Thank you for your letter dated 9 November 2023 notifying me of the proposed erection of a single storey extension with roof terrace above, external alterations and extension of existing garage at 8 Boulder Gate, Marsden (application 2023/93205).

Having viewed the application, including plans and documentation on the Kirklees planning portal, I would like to object to the single storey extension with roof terrace and patio doors above – I do not have any objections to the internal alterations and the extension of the existing garage.

Drawing Title:
Site Block Plan as Proposed

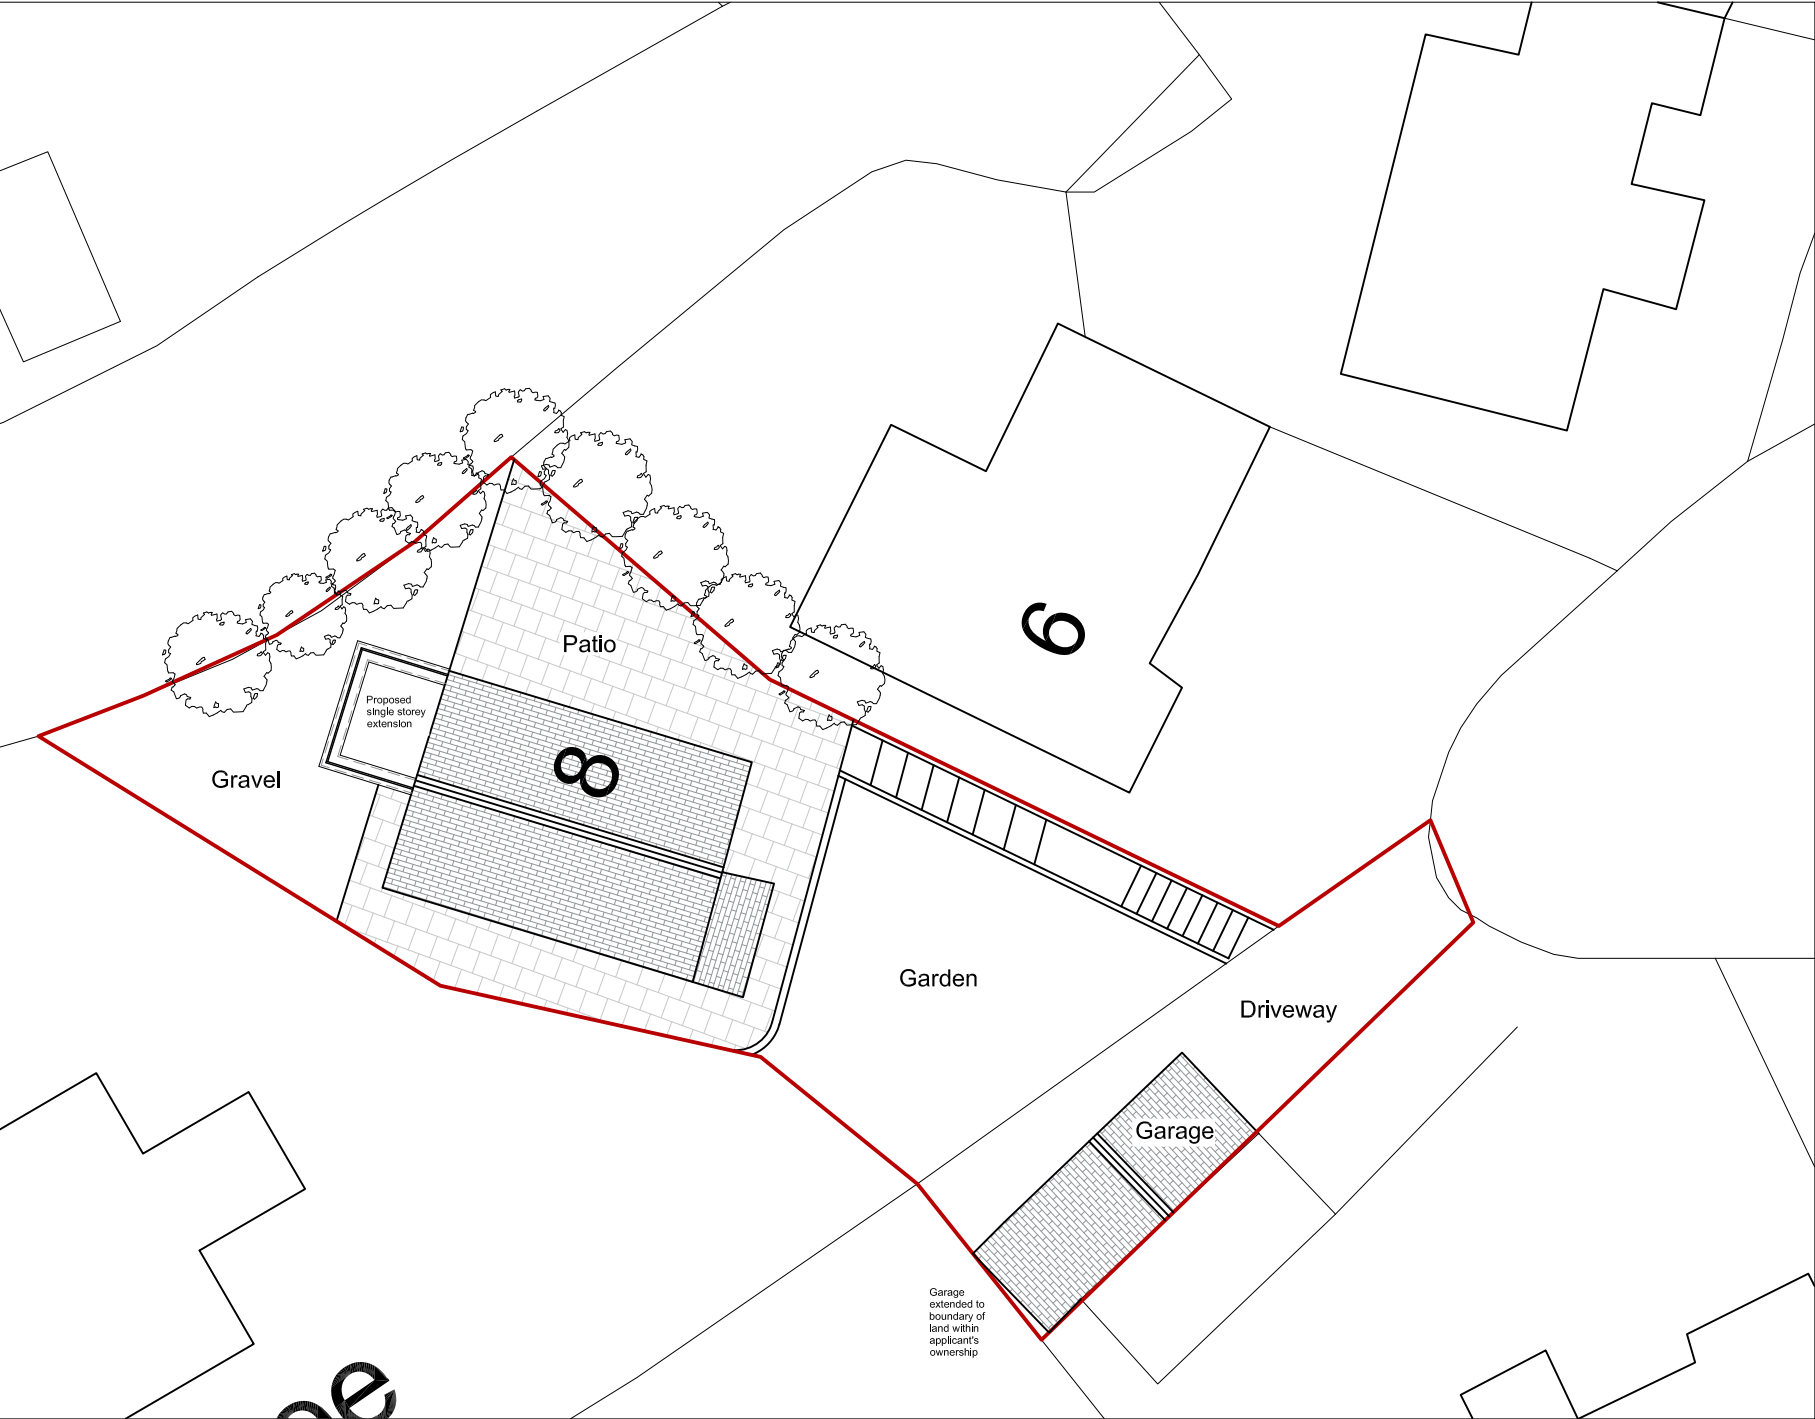
- a. The Location Plan (i.d. 1014916), Proposed Site / Block Layout (i.d. 1014915) and the Location Plan included on the Group Plans and Elevations as Existing drawing (i.d. 1014906) are all extremely misleading, showing an incorrect orientation of 8 Boulder Gate. The ridge of 8 Boulder Gate (that runs from west to east), is shown on the west side to be considerably above the horizontal facing away from my property. In reality, the ridge runs on a line below the horizontal, with the west elevation facing towards my property at Cartref and not across the valley towards Sparth as is shown on the drawings submitted by the applicant. This is obvious on site and can be seen clearly on the Kirklees Council KOMPASS map accessed via the 'view application on a map' link on the Kirklees planning portal and on Google Earth/Maps.
